September 14, 1988

RE: GRADING/PAVING PLAN FOR MOUNTAIN BELL @ 2327 ALAMO, SE
(M-16/D3A) REVISION DATE OF AUGUST 26, 1988

RE: DRAINAGE PLAN FOR MOUNTAIN BELL @ 2327 ALAMO, SE
(M-16/D3A) RECEIVED AUGUST 9, 1988

SHEET
C 1

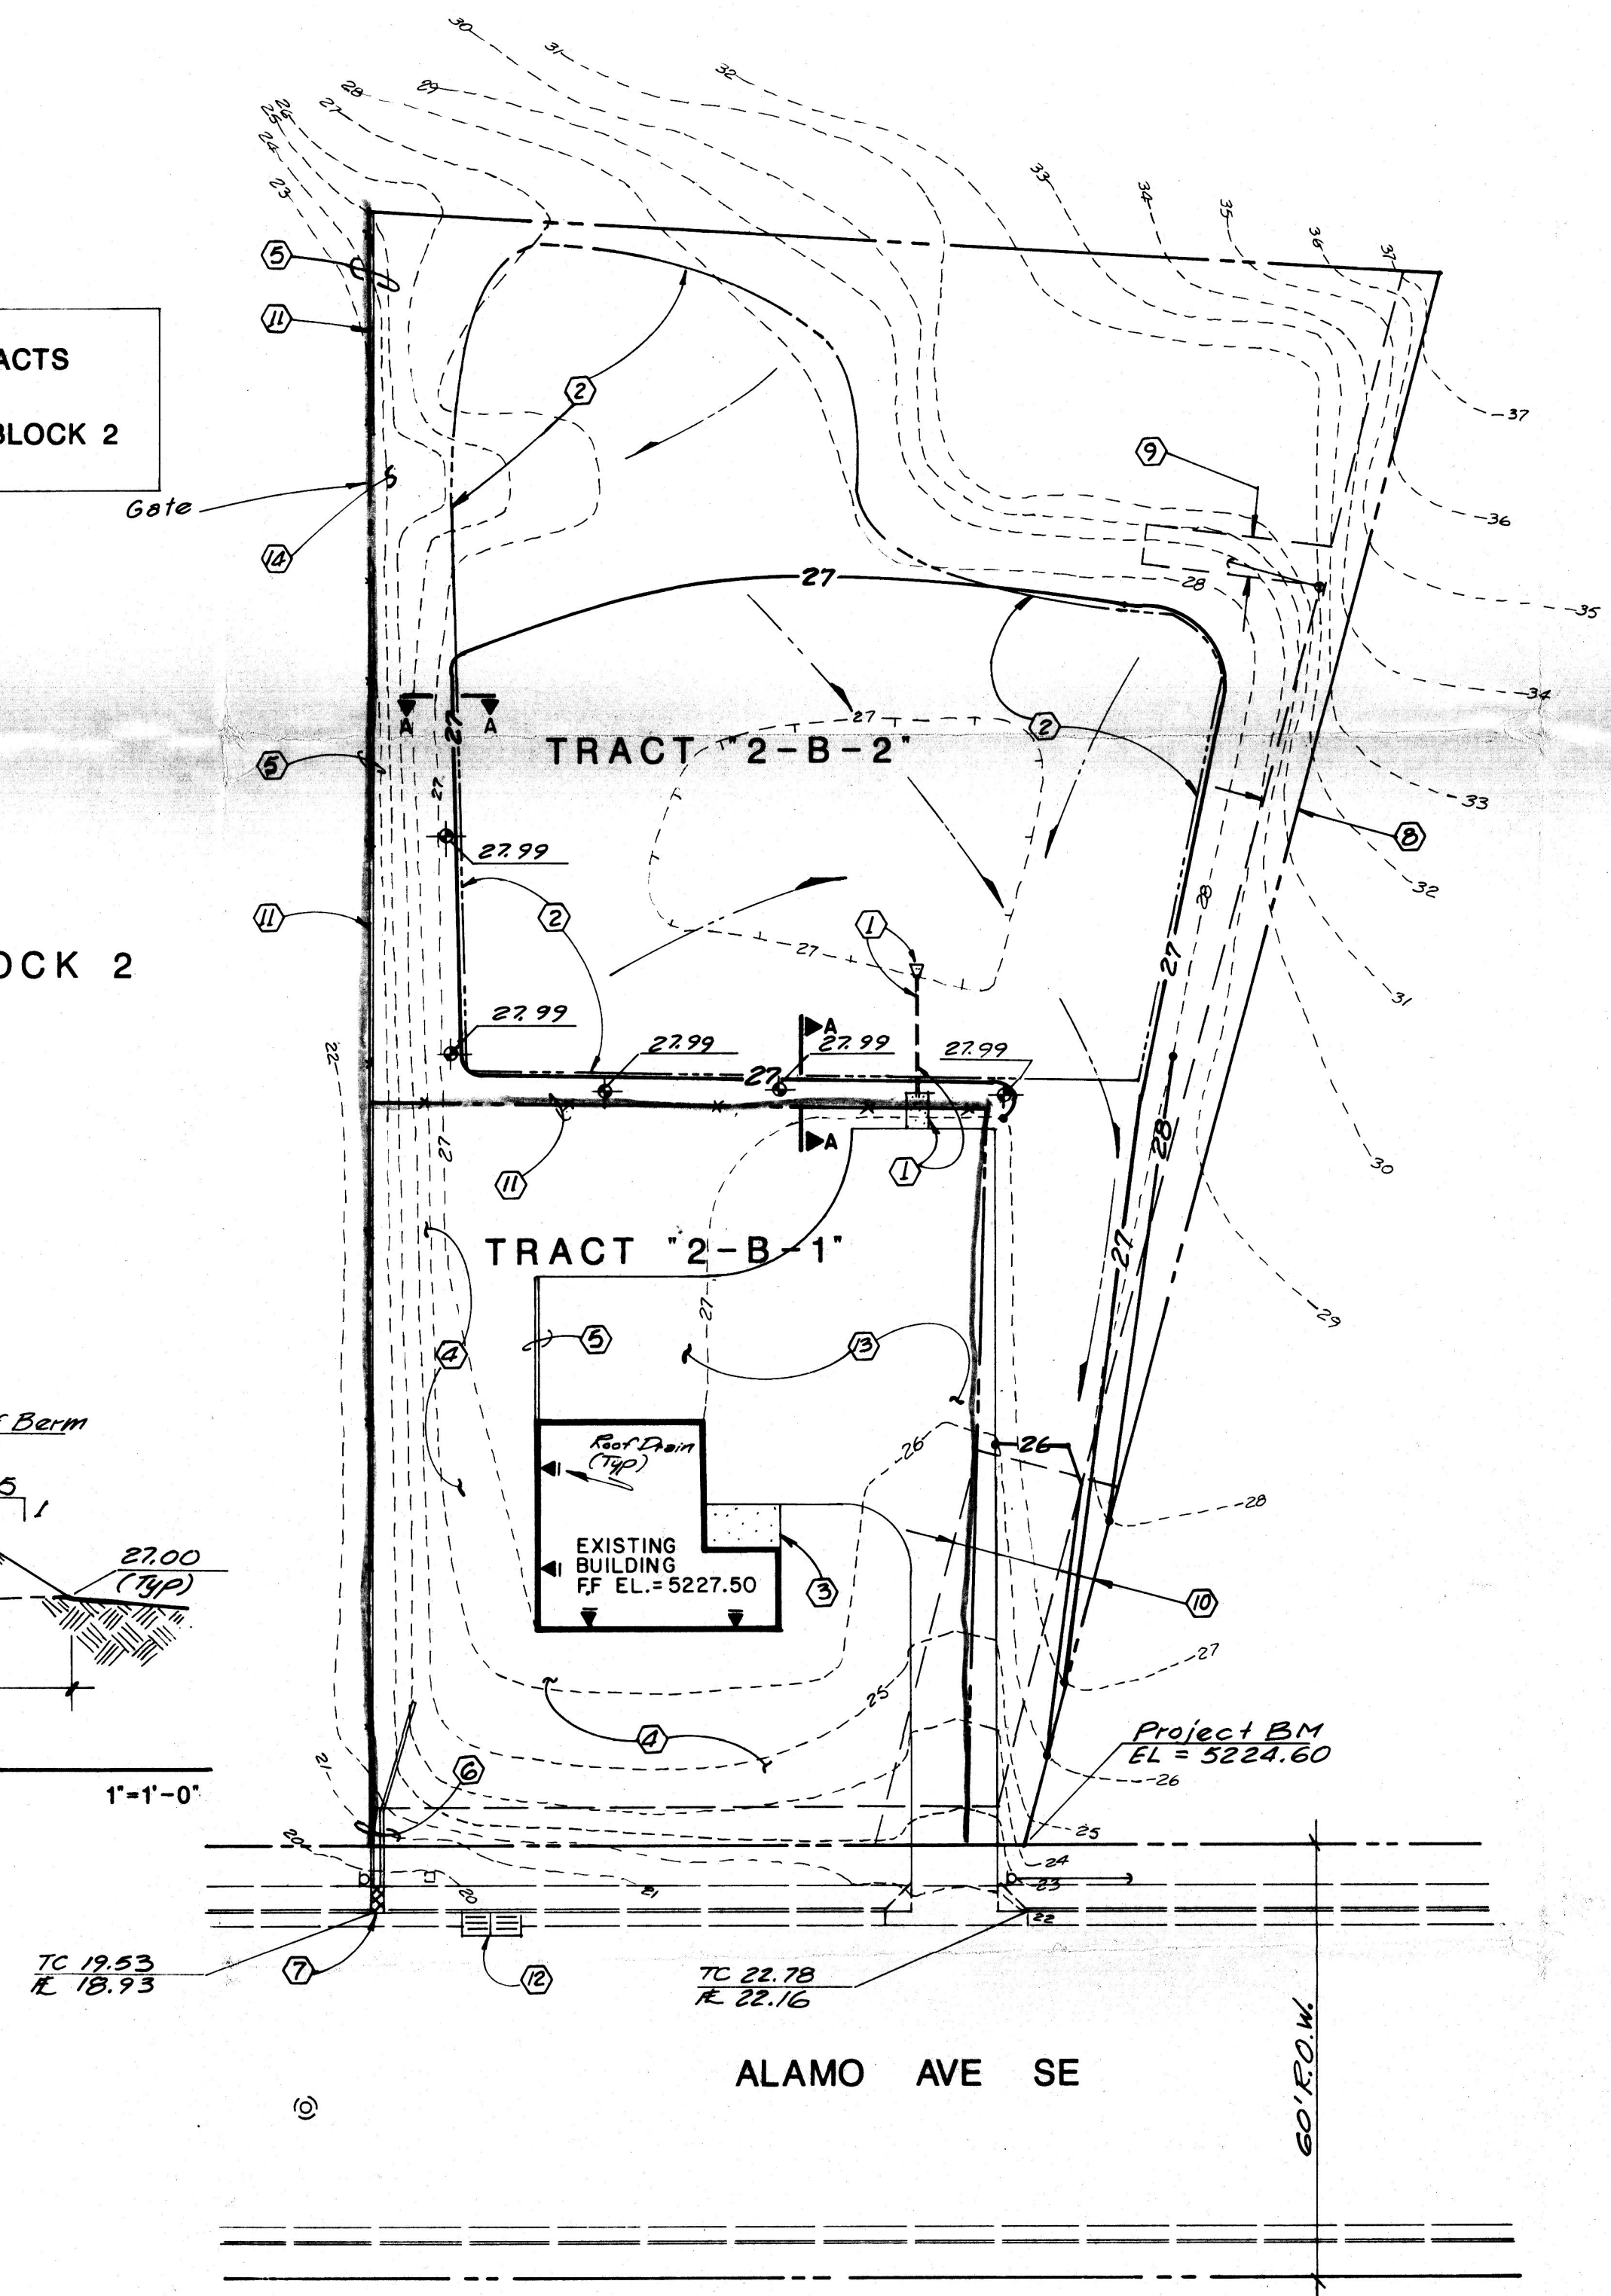
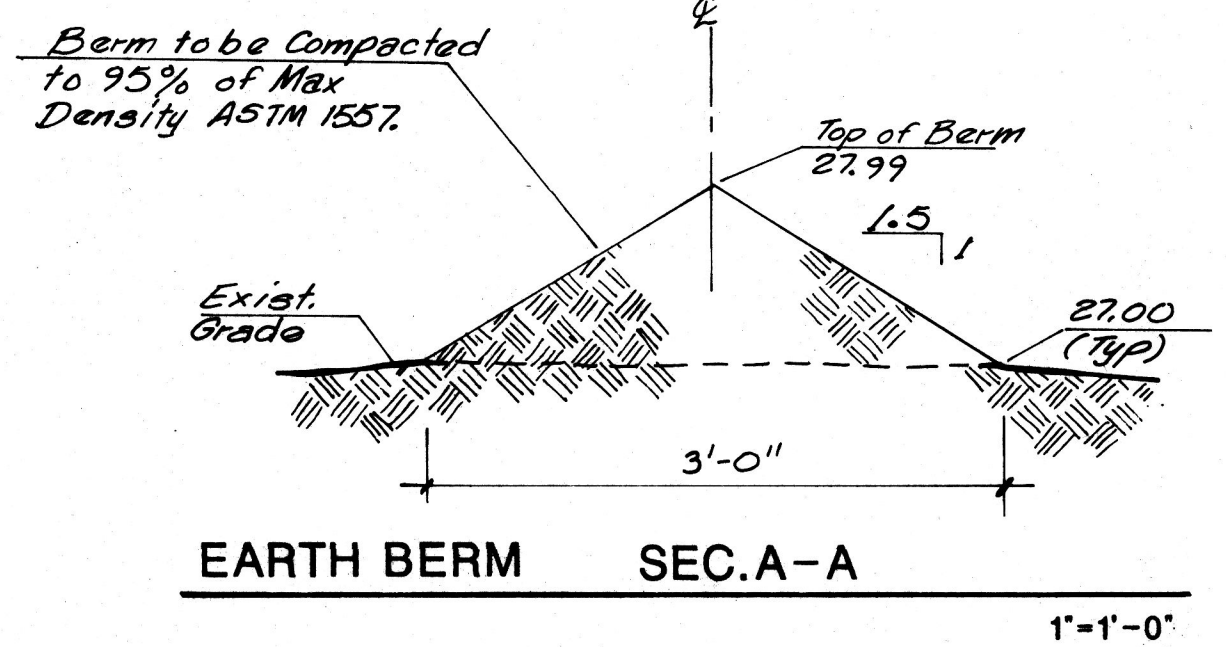
1. Quantification of offsite rate of flow caused by the contributing watershed. You must accept the offsite flows from the existing undeveloped site to the east.
2. Once the offsite flows enter the site, how do you propose to handle them.
3. We will need an easement or replat for cross lot line drainage. Even if the properties are owned by the same owner, we will need something that will run with the land.
4. What type of compaction specifications do you propose for the earth berm.
